CITY OF PORTLAND

BUILDING PERMIT

Job ID: 2012-09-5020-ALTR

has permission for Removal of exist stairs; rebuild new two (2) level deck (Two Family Residence).
provided that the person or persons, firm or corporation accepting this permit shall comply with all of the provisions of the Statues of Maine and of the Ordinances of the City of Portland regulating the construction, maintenance and use of the buildings and structures, and of the application on file in the department.

IF THIS SHEET IS NOT 24 X 36 IT IS A REDUCED SCALE PRINT - SCALE ACCORDINGLY

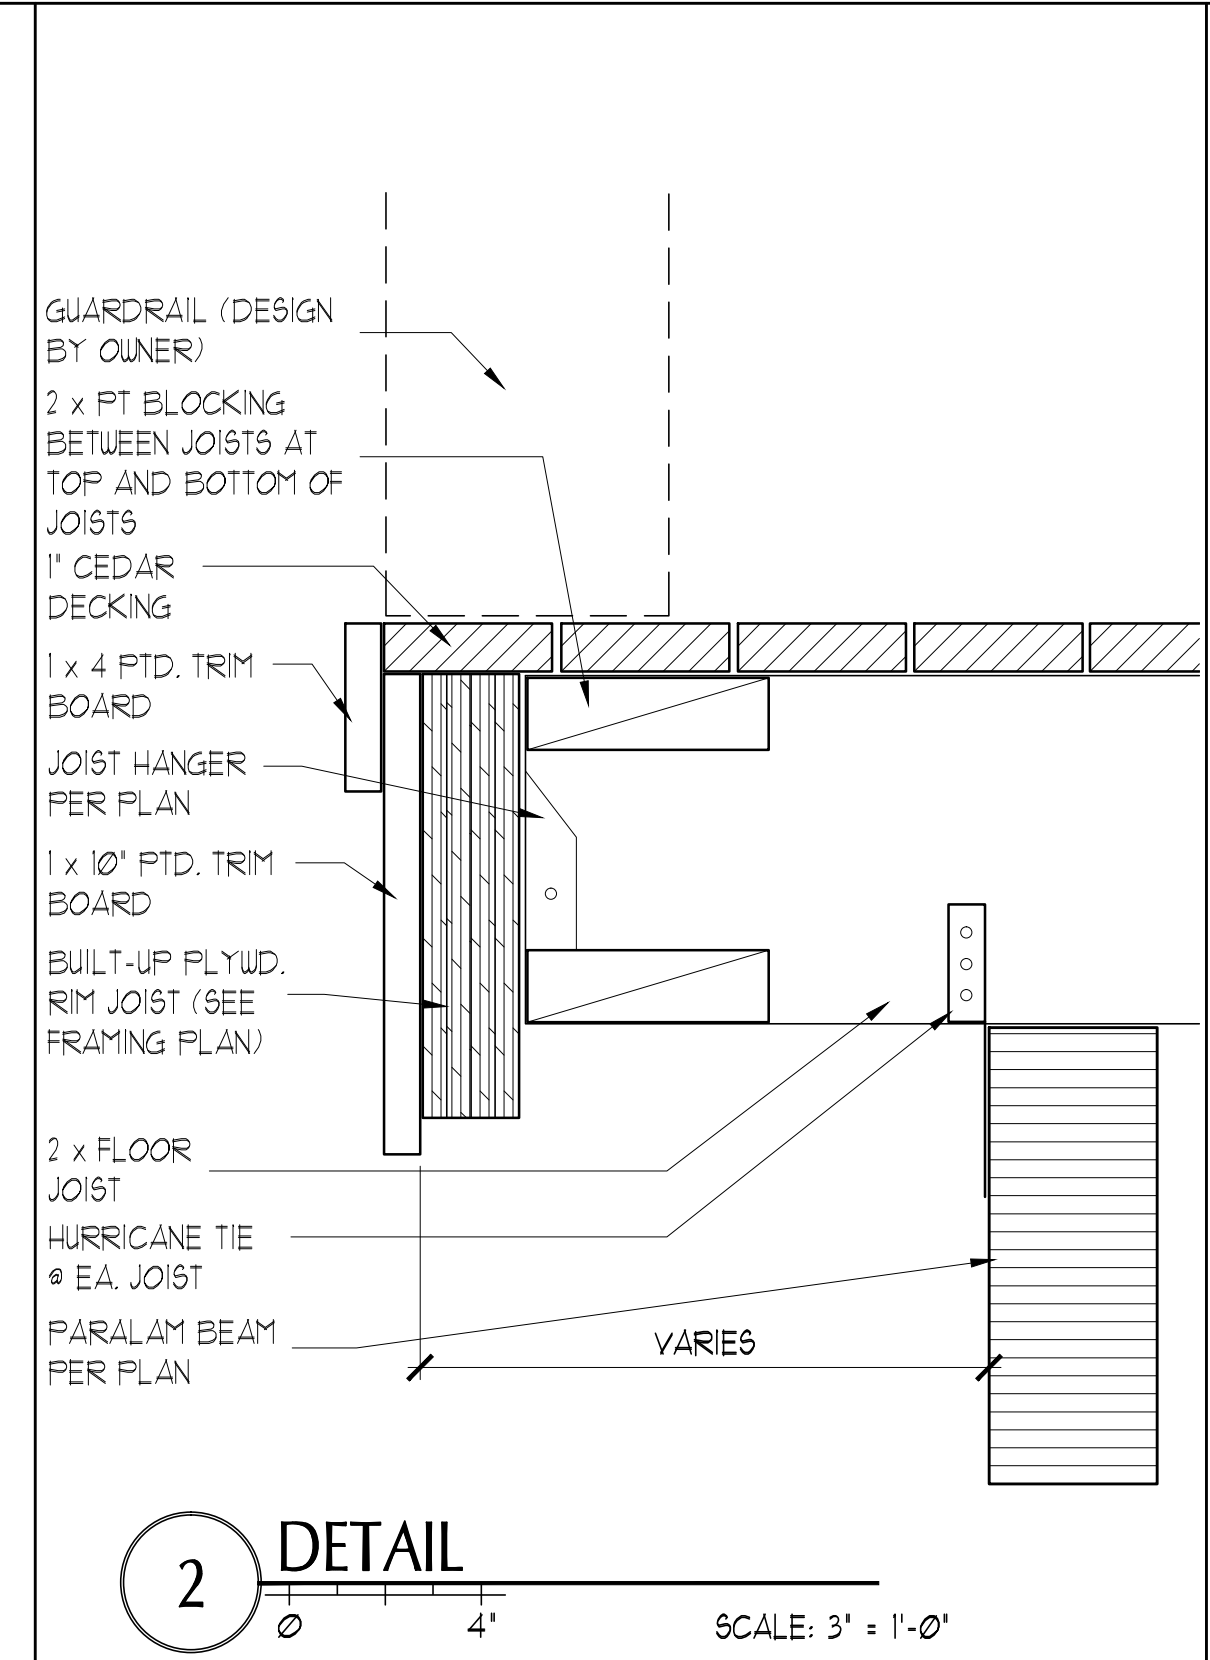
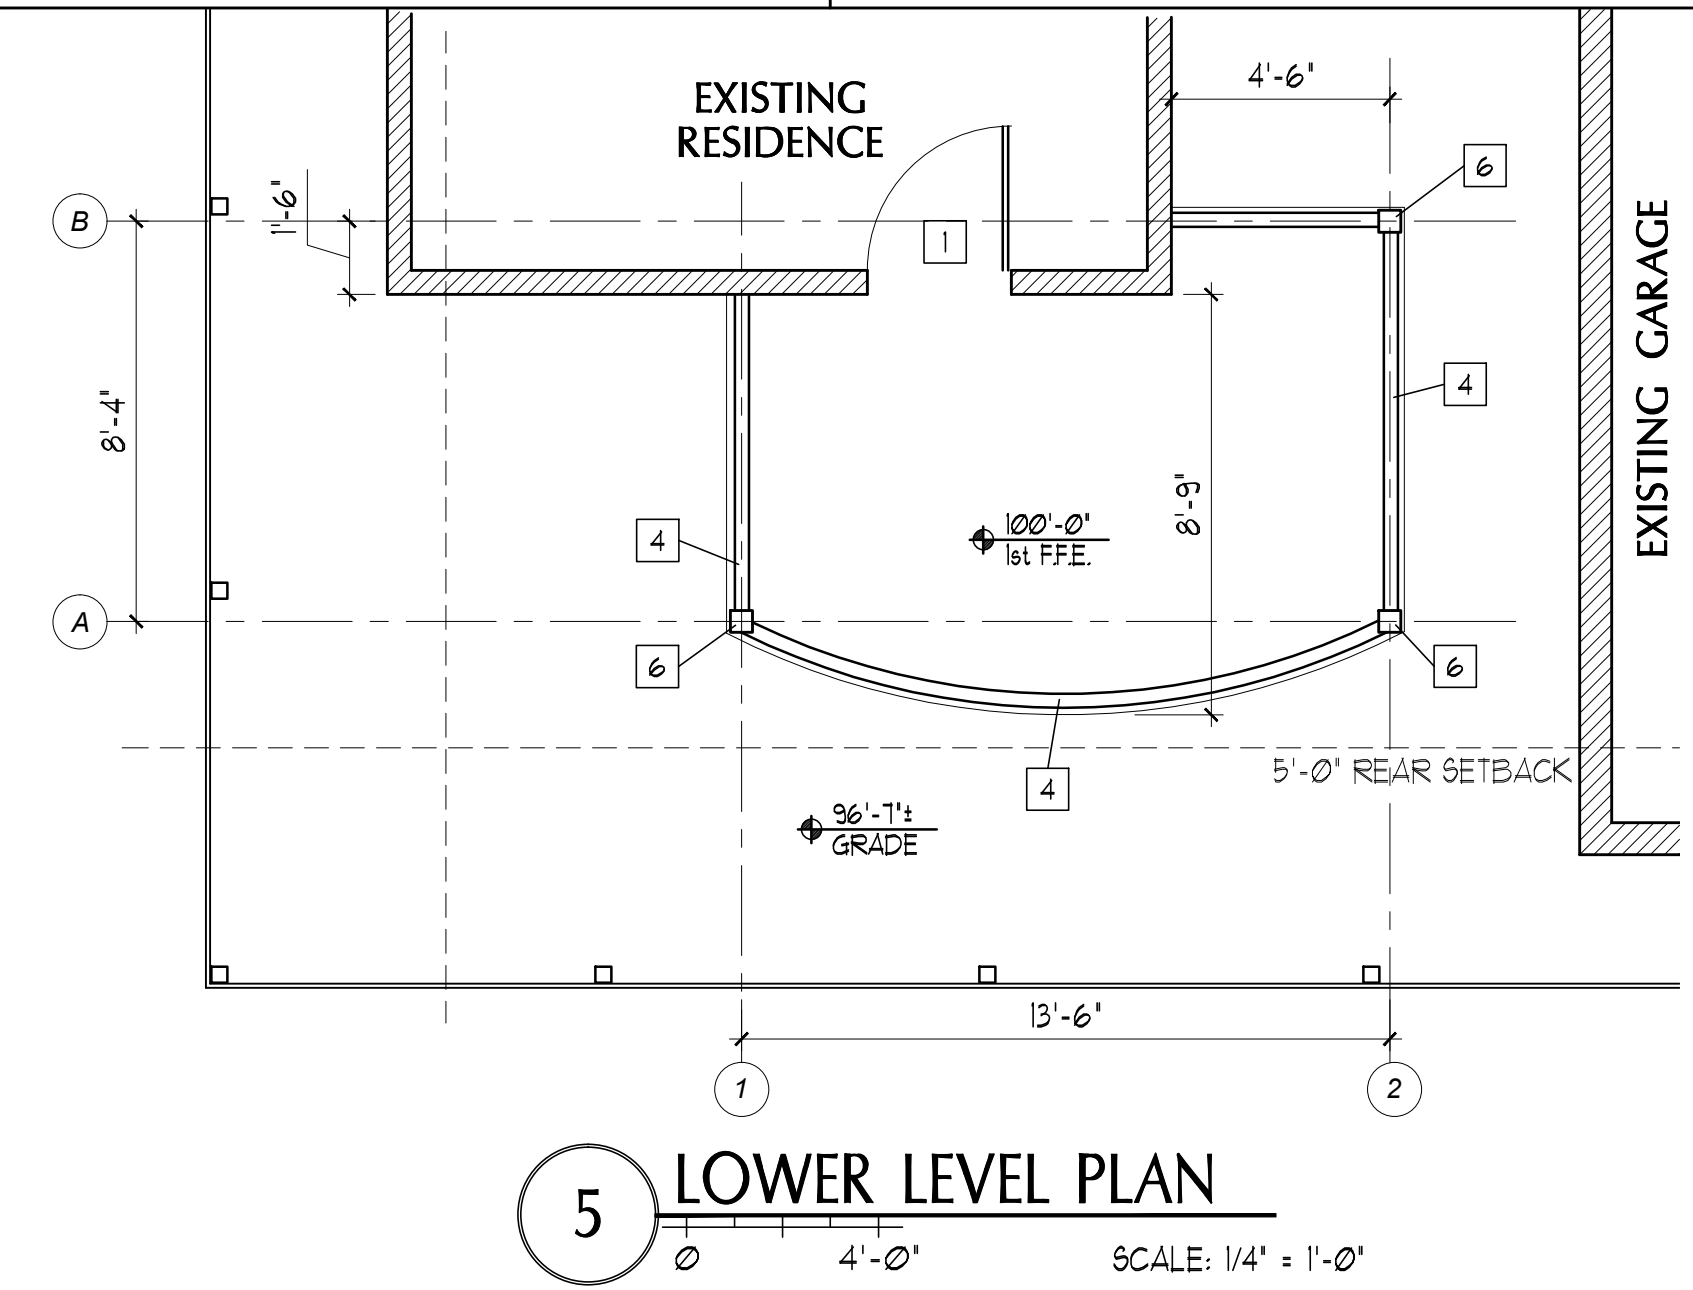
- a. Note: Architect stated that both units have independent means of egress.
3. A graspable handrail (34-38 inches in height) shall be provided on at least one side of each continuous run of treads or flight with four or more risers. Fall protection (36 inches) from exterior decks may be required if floor joist are at or above thirty (30) inches from grade.

4. R312.3 Opening limitations. Required guards shall not have openings from the walking surface to the required guard height which allow passage of a sphere 4 inches in diameter.

6. R311.5.1 Attachment. Exterior landings, decks, balconies, stairs and similar facilities shall be positively anchored to the primary structure to resist both vertical and lateral forces or shall be designed to be self-supporting. Attachment shall not be accomplished by use of toenails or nails subject to withdrawal.

1. The square footage is measured to the edge of the deck - the dimensions on the plan seem to go to the middle of the columns. This is important because you are saying the footprint is 170 sf which gives you exactly 50% lot coverage. You also need to include the footprint of any landing and stairs that are not shown on the assessor's footprint.
2. For the square footage of the deck, did you figure in the footprint of the stairs from the lower level?
3. Besides the 50% lot coverage, you also need to show that there is 20% open space. Open space is the area that is not covered by impervious surfaces (footprint of structures & any pavement).

As we last left off, we were ascertaining the maximum size of the deck that would be possible. However, we did run into the issue of 50% building coverage. When we talked last, you explained that any entry steps would be included in the building coverage numbers as well as impervious surface. Upon measuring the steps into the residence, it was determined that the deck needed to be reduced by quite a bit. This required analysis by the owner to determine if they still wanted to go through with the project as they would lose a section of the deck. If you remember, there was an intermediate level to the deck. This area would have to be eliminated.

Area left for new deck: $3040 \text{ sf} \times 50\% = 1,520 \text{ sf} - 1,395.8 = 124.2 \text{ sf}$ (Therefore, we made the new deck to be 124 sf). See attached (we had to adjust it the size to make it slightly smaller).

Impervious surface: $(1,141 + 209 + 40.8 + 5 + 124 + 607 + 16 + 33.4) = 2,176.2 \text{ sf}$ (...with 255.8 sf left to spare).
